Government Authority Responses

RE: PROJECT APPLICATION FOR FERN BAY ESTATE

Re: Draft Master Plan Proposal – Fern Bay Estate, Nelson Bay Road, Fern Bay (MP 20-4-2005).

**Project Application for Fern Bay Estate
Nelson Bay Road, Fern Bay**

Figure 1

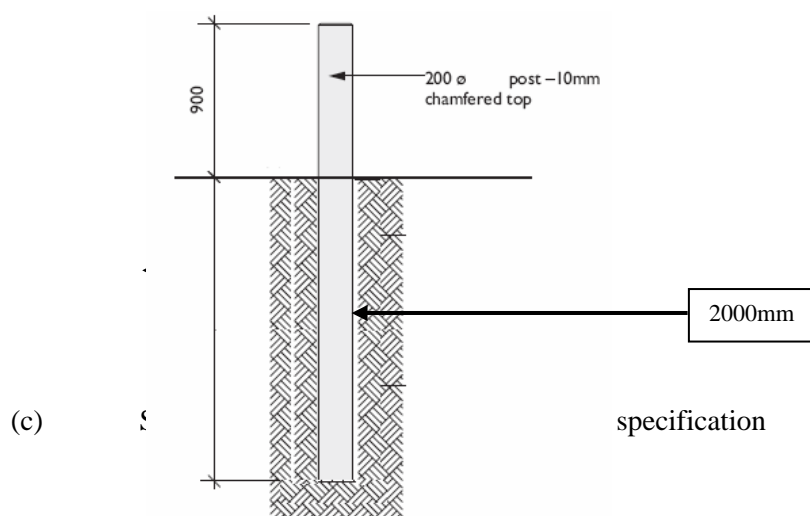
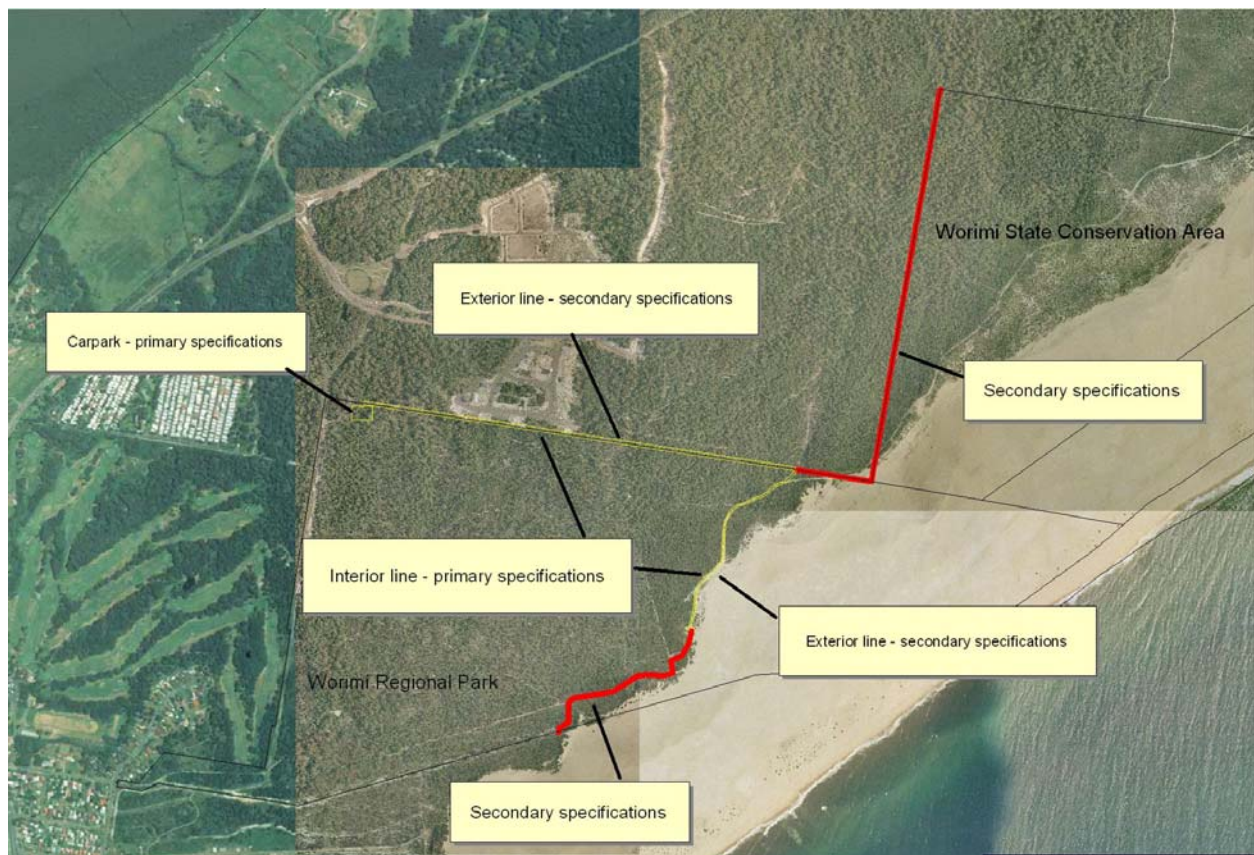
- Bollard and cabling of four wheel drive track, and Aspen/Worimi State Conservation Area boundary as agreed needs to be included.
